WELWYN HATFIELD COUNCIL – DEVELOPMENT CONTROL
DELEGATED REPORT

APPLICATION No:	N6/2008/2492/FP & W6/2008/2493/EM
------------------------	--

DESCRIPTION OF PROPOSAL: It is proposed to erect a two storey side extension and a single storey rear extension.

Drawing No: 2414-P-01 Revision: C

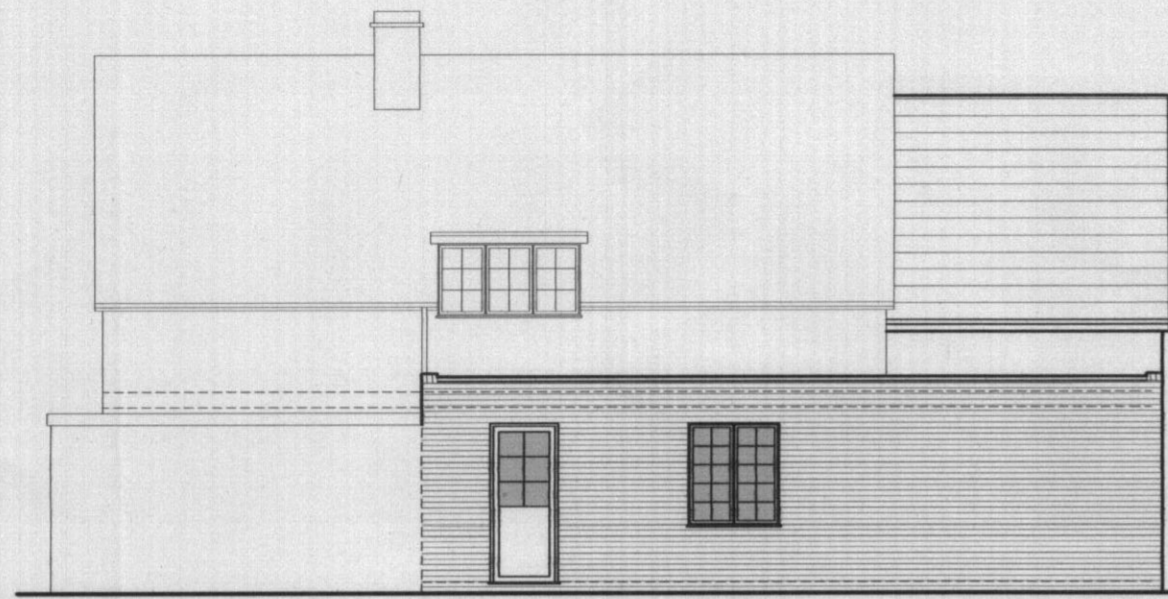
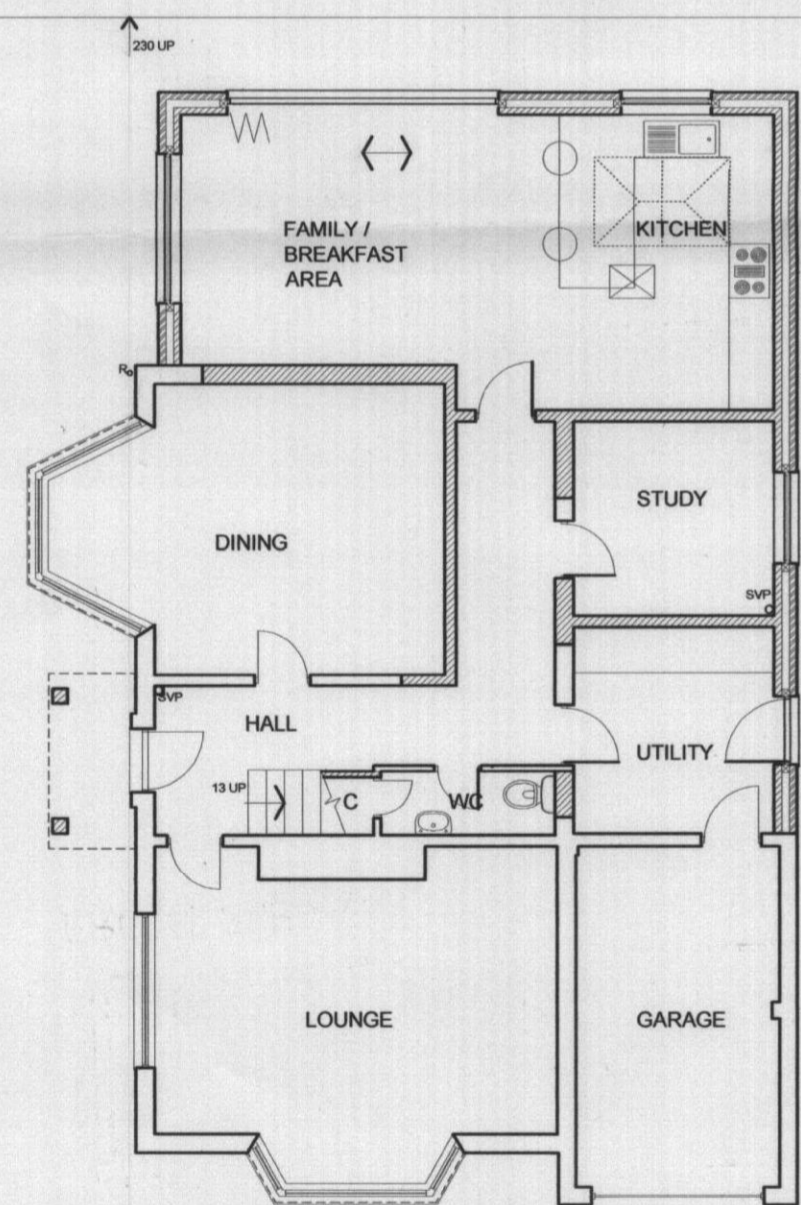
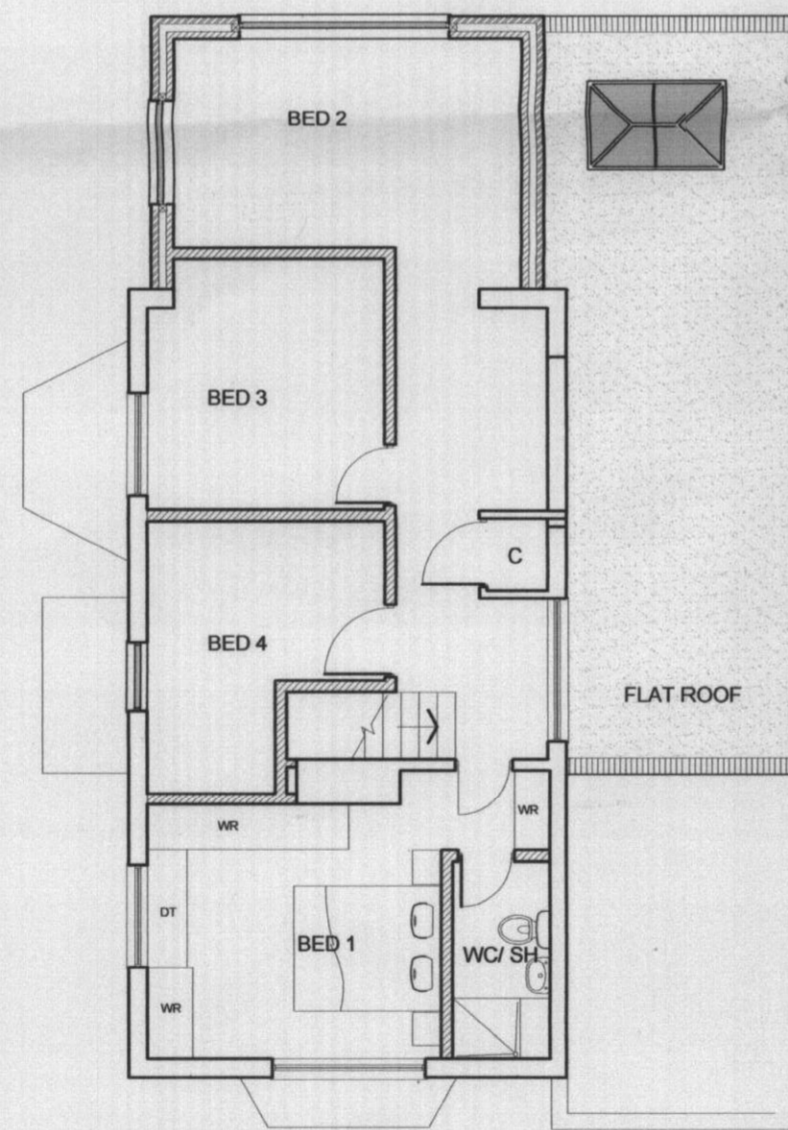
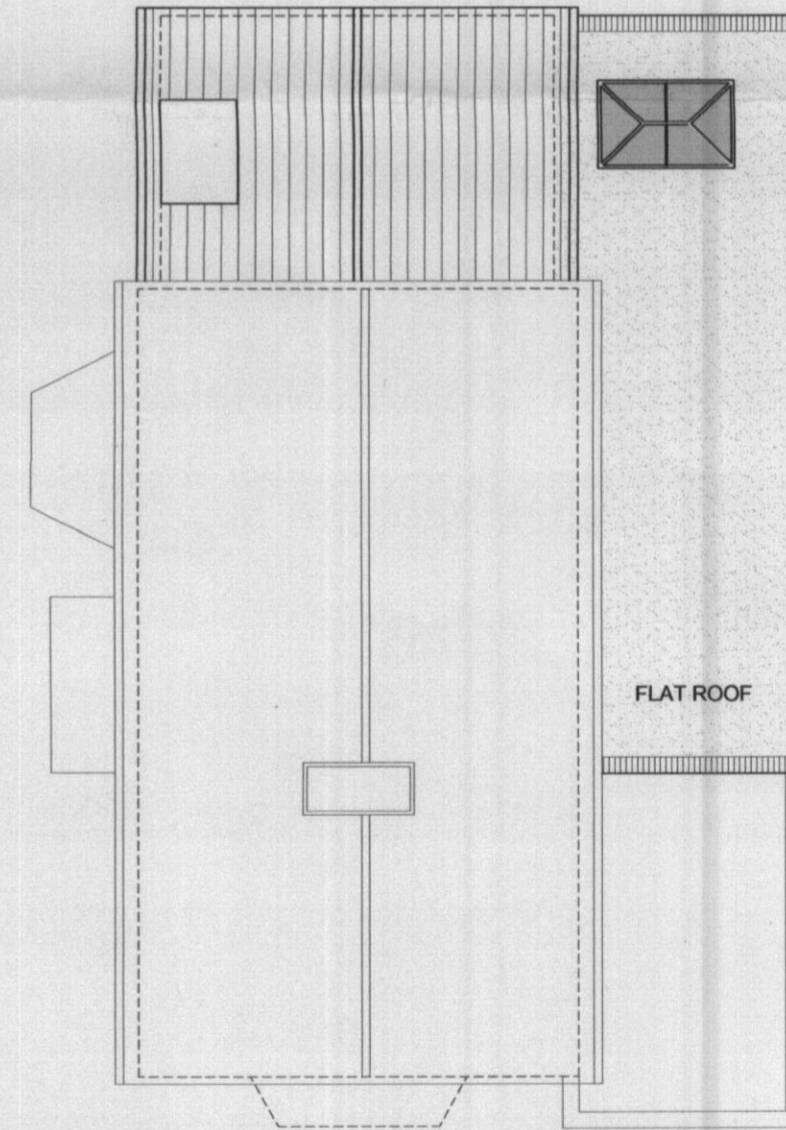
The Welwyn Garden City Society objects to this application. This proposal, by virtue of its design, form, siting and scale, would fail to respect the design and form of the existing dwelling and form an overly dominant feature on the dwellinghouse that would fail to be subordinate in scale. Accordingly it is considered that the proposal would fail to preserve or enhance the character and appearance of the conservation area contrary to PPS1, PPS3, PPG15 and Policies SD1, GBSP2, R22, D1 and D2 of the Welwyn Hatfield District Plan 2005 and the Supplementary Design Guidance; Statement of Council Policy 2005. The application should be refused.

The proposed single storey rear extension would be sited to the rear of the existing garage and the rear elevation of the extension would adjoin the northern boundary shared with neighbours at 23 Roundwood Drive. It would have a flat roof, encased by a parapet wall, would be of matching facing brickwork and would be widely screened from the surrounding area. It is considered that the scale, design and siting of the extension would have no material impact on the character and appearance of the area and is considered to be appropriate in this location.

The two storey element of the proposal would be sited in a more prominent location. Its form and fenestration would respect the parent dwelling, and it would also be of matching facing brickwork. The gable would be set in from the front and rear elevation and subsequently the ridge and eave height would be lower. Accordingly it is considered that the proposal would be subordinate in scale and the proposal would sufficiently preserve the character of this dwelling

The dormer window would be sited centrally in the front of the roof, between the two existing dormers. It would respect the existing fenestration and would not unbalance the property. It is considered that this element of the proposal would also preserve the visual amenity of this property.

2. The single storey extension would be sited approximately 3 metres and the two storey extension would be positioned to be approximately 10 metres from the nearest dwelling of 23 Roundwood Drive. 23 Roundwood Drive is sited to the north of the application site, although it is considered that the degree of separation combined with the scale of the proposal ensures that the proposed side extension would not have an unreasonable impact on the light that is afforded to the neighbouring residents.

The majority of the windows would face onto the main area of amenity space to the eastern side of the dwelling and 4 Reddings is largely screened by the vegetation at the base of the garden. One window in the single storey extension would face towards 23 Roundwood Drive, although this would only face out onto the boundary treatment. It is considered that the proposed development would not have a detrimental impact on the privacy of the neighbouring residents to an extent that would justify the refusal of the application on those grounds.
